**Thomas Street Car Park, Chatswood**

**MP09\_0066 MOD 7**

***Below ground basement amendments, including replacing the sloped aisle system with a ramped system, collocating of the public car parking spaces, relocating lift cores; and minor increased depth of excavations.***

Director-General's  
Environmental Assessment Report  
Section 75W of the  
*Environmental Planning and Assessment Act 1979*

BASEMENT 2 PLAN

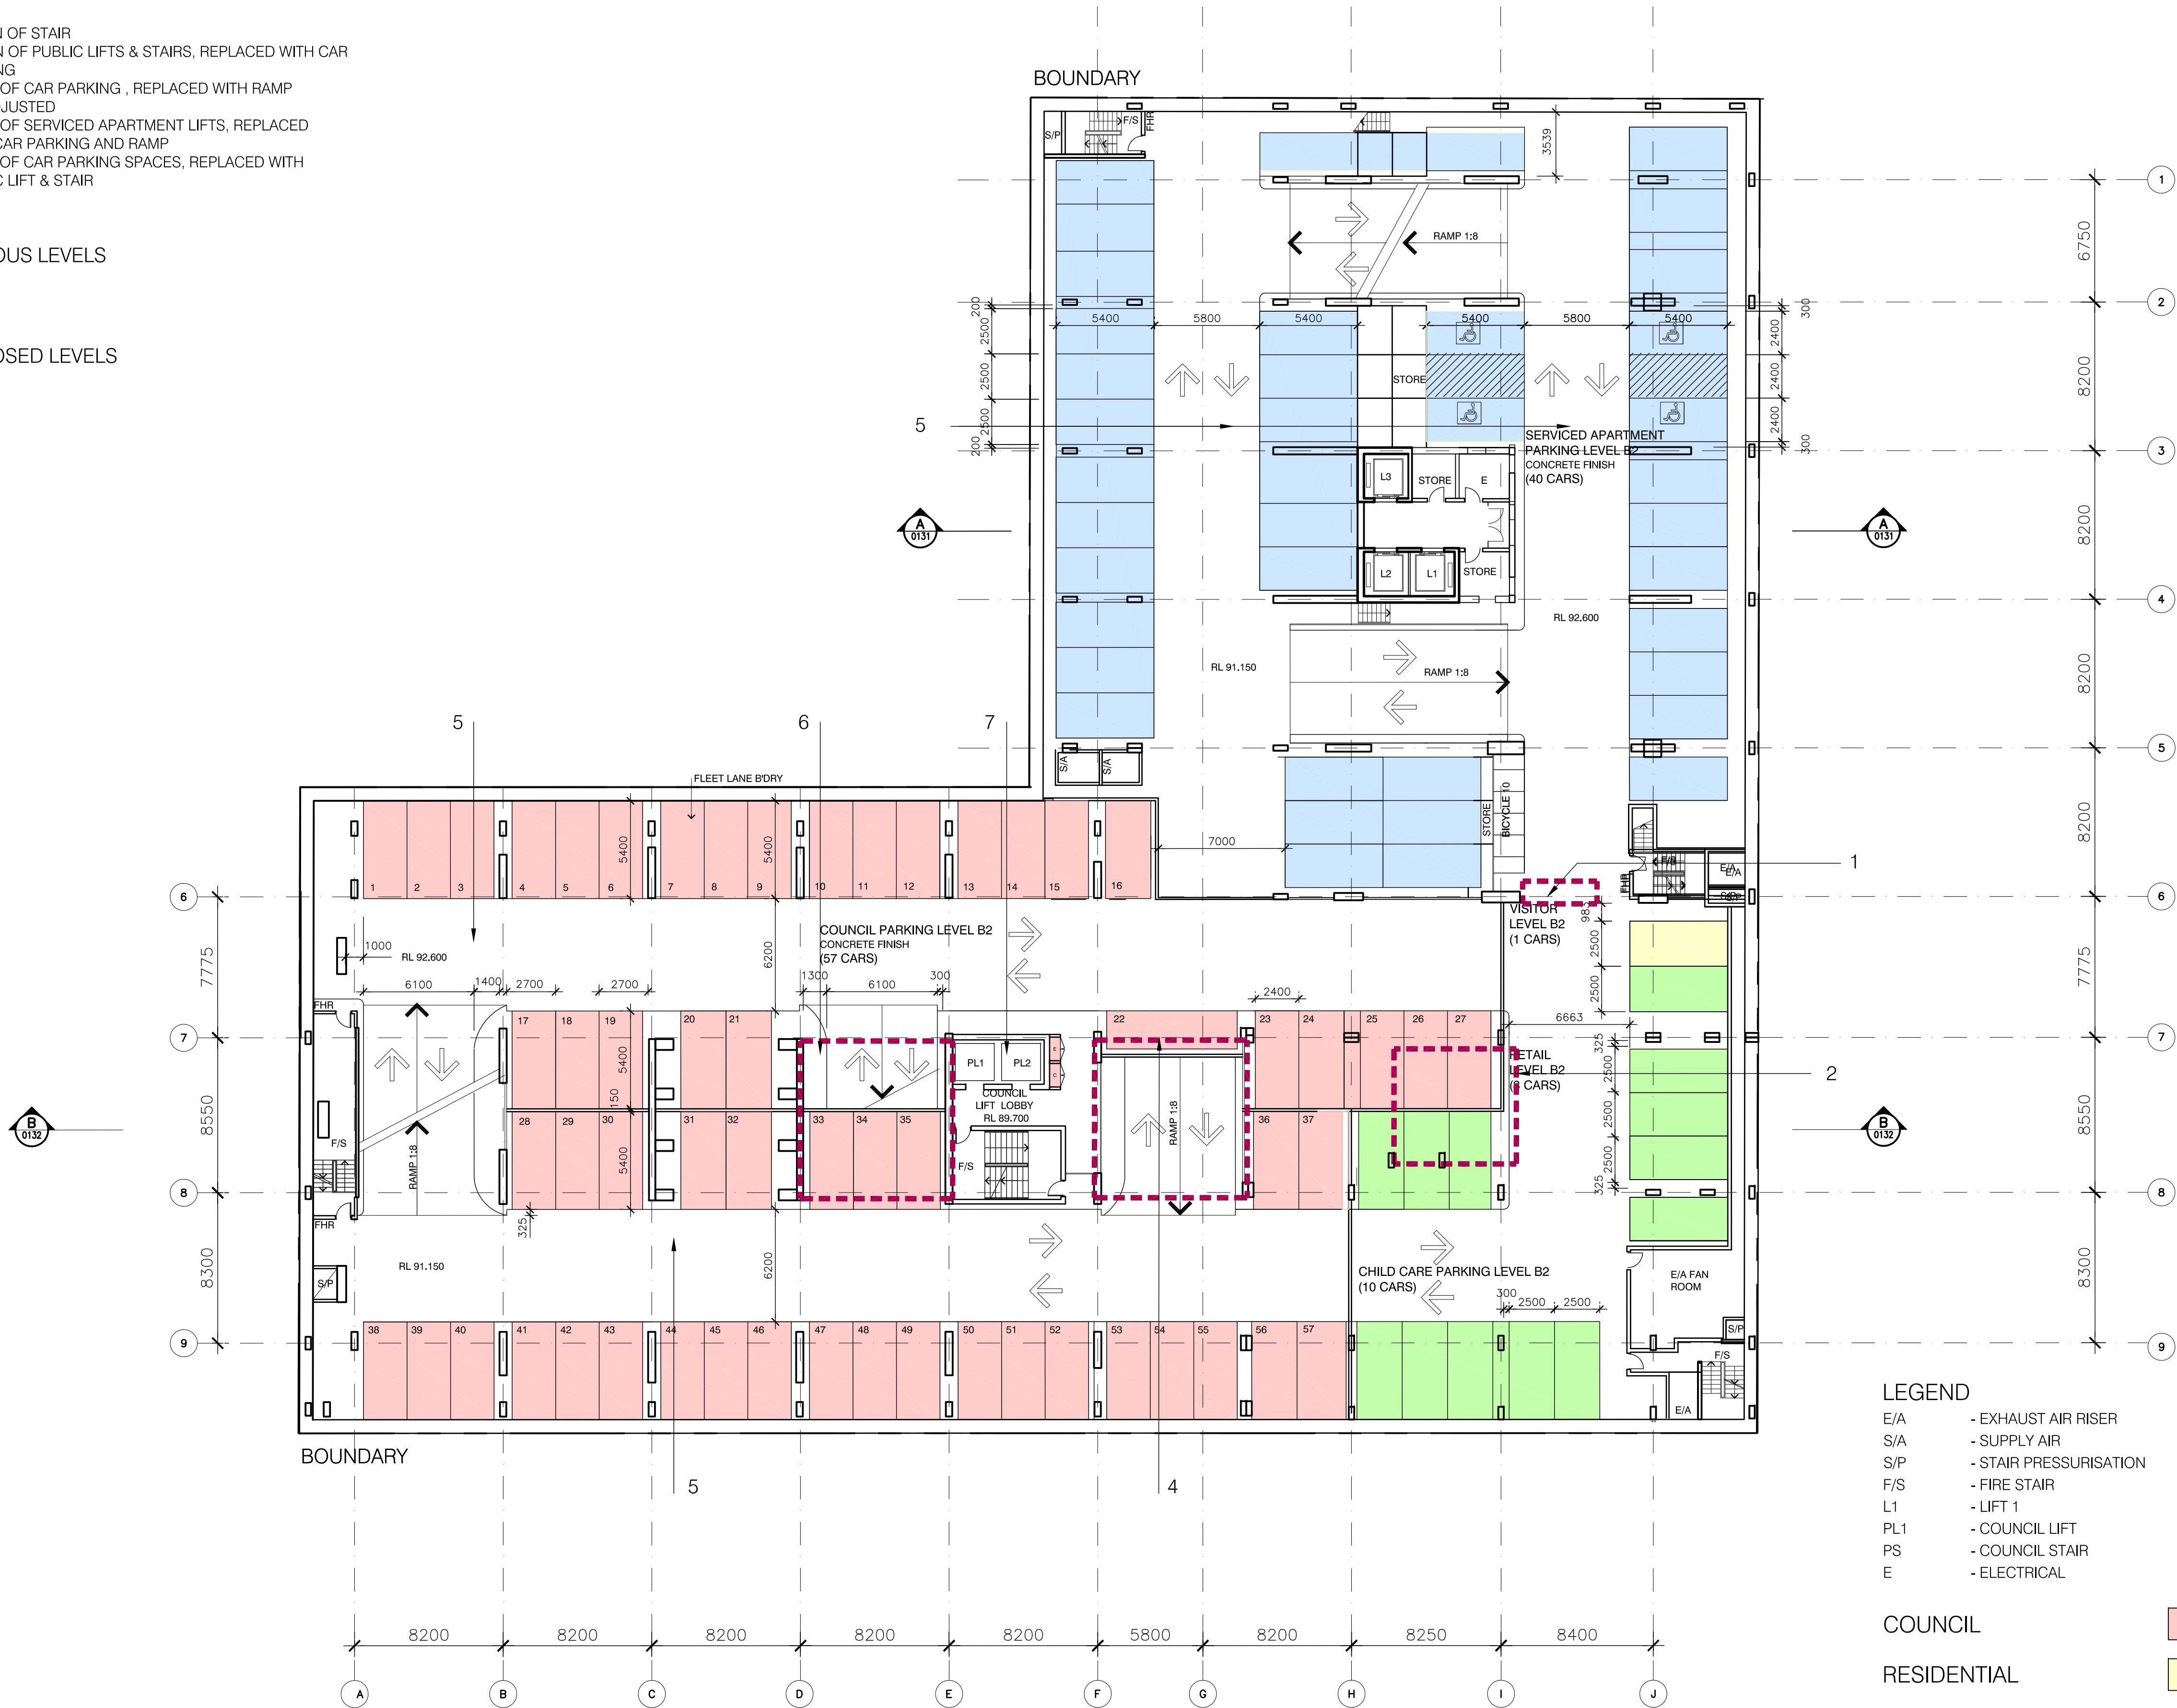
- its preference for further consolidating and separating the carparking from the other basement uses, including its access lifts;

- its preference that serviced apartment users did not access carparking through the public carpark;
- its preference that Council's approval be required for any changes to plans affecting the public carpark by reinstating earlier wording of condition B15; and
- errors in the plans relating to the numbers of lifts and written floor levels.

- further consolidating and separating the public carpark from other uses;
- relocating the serviced apartment carparking to the northeast part of the basement so that it is not accessible through the public carpark; and
- correcting errors in the plans.

1 BASEMENT 5 PLAN
1:200

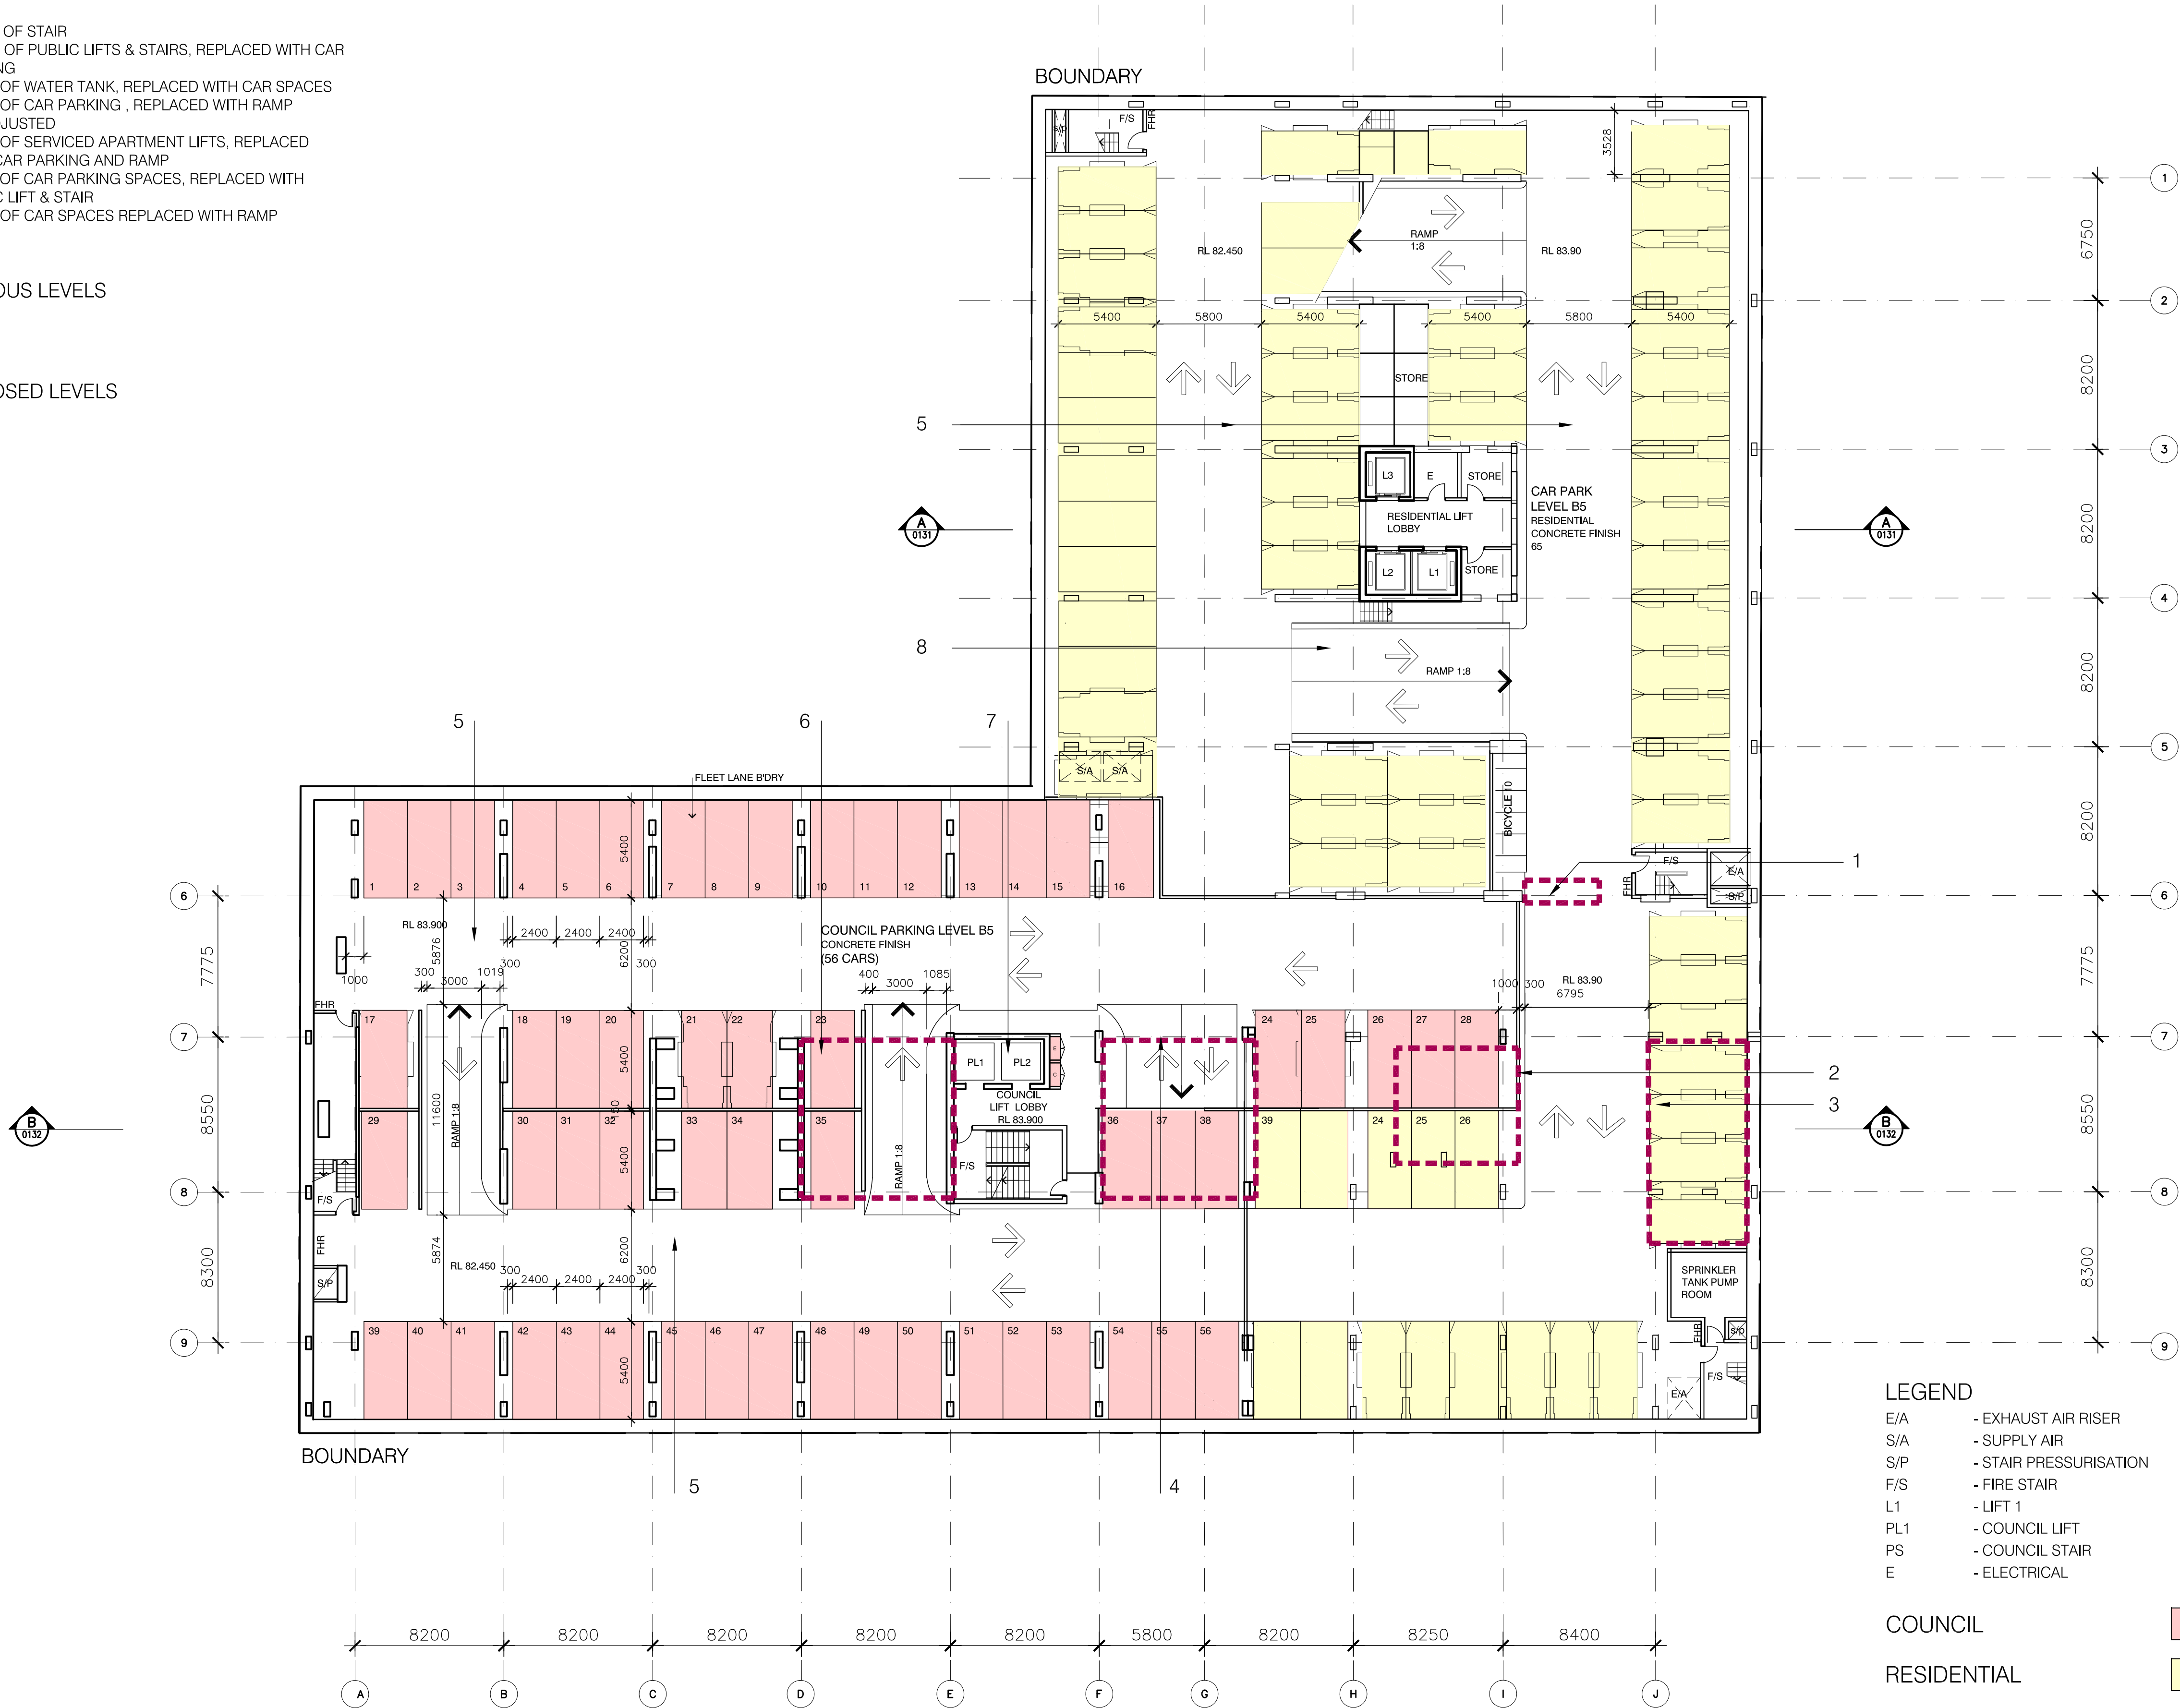
The Department notes that the modification proposes to lower the level of Basement 5 from a minimum finished floor level of RL 83.35m to RL82.45m. The extent of additional excavation is approximately 900mm.

Department considers that these impacts are adequately addressed in the assessment of the original application and the conditions of approval. The proposed modification is considered not to give rise to any new impacts which require additional consideration and/or amended conditions.
